From: RATHAN Pahee <Pahee.RATHAN@rms.nsw.gov.au>
Sent: Sunday, 23 November 2014 12:17 PM
To: David Mooney
Subject: RE: Moorebank Recycling Facility, Part 3A application, Additional traffic information (Liverpool LGA)

I refer to your email regarding the additional traffic information for the Moorebank Recycling Facility.

Roads and Maritime has reviewed the additional information and notes that, in accordance with the information submitted by McLaren Traffic Engineering, traffic control signals are not required to service the combined development of Marina and Recycling Facility in terms of traffic volume.

**5 ATTACHMENT C – PROPOSED INTERSECTION WITH SWEPT PATHS BY
MCLAREN**

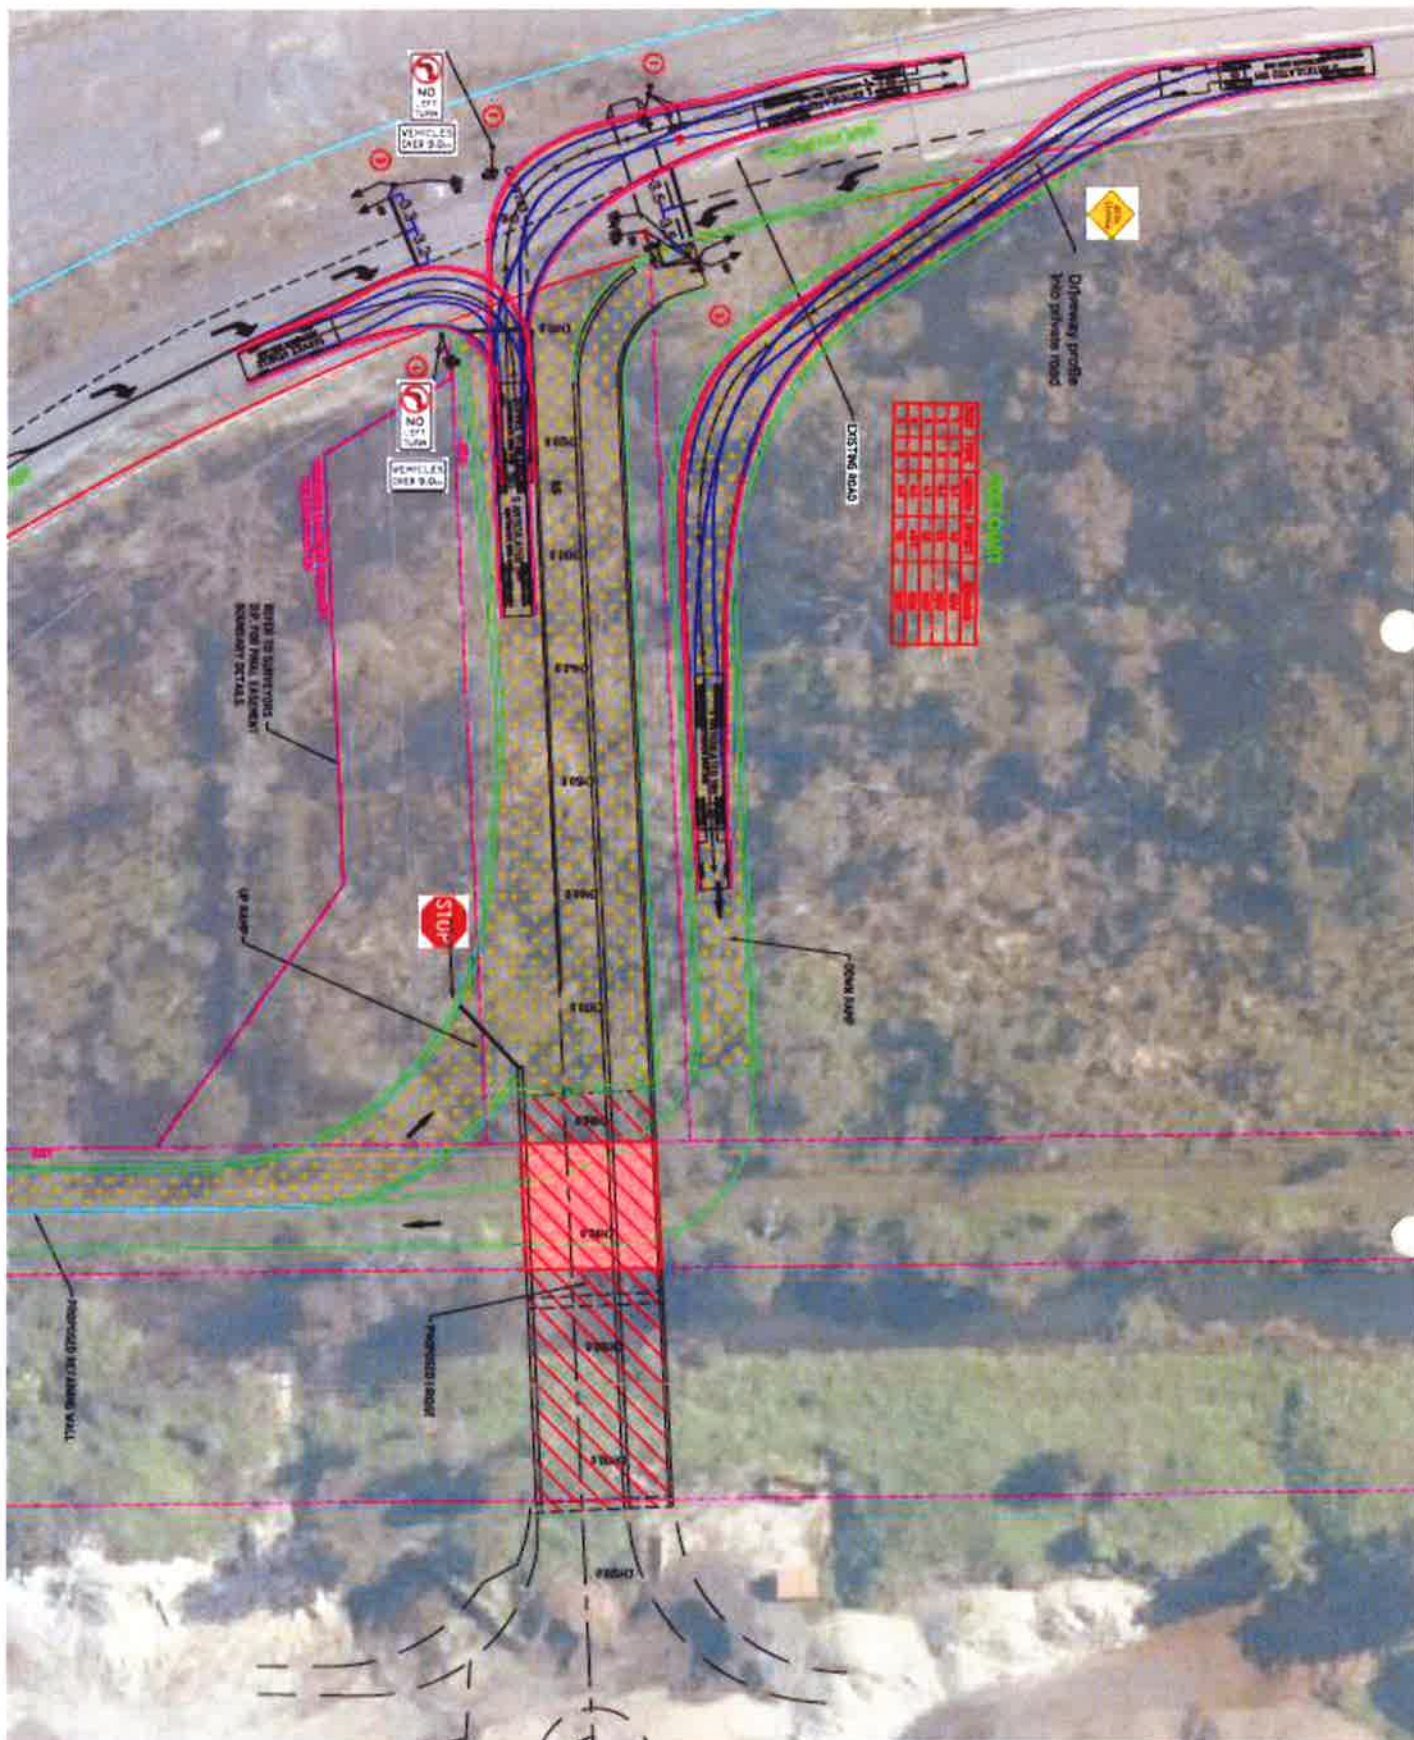
However, the traffic consultant was trying to argue for a special case to provide traffic control signals without providing any actual details of crash history, actual sight distance issues etc at this location.

In other words, the proposed intersection would operate efficiently under priority control and there are no known safety issues at this location.

Therefore, based on the information provided, Roads and Maritime does not support the provision of traffic control signals to service the combined developments.
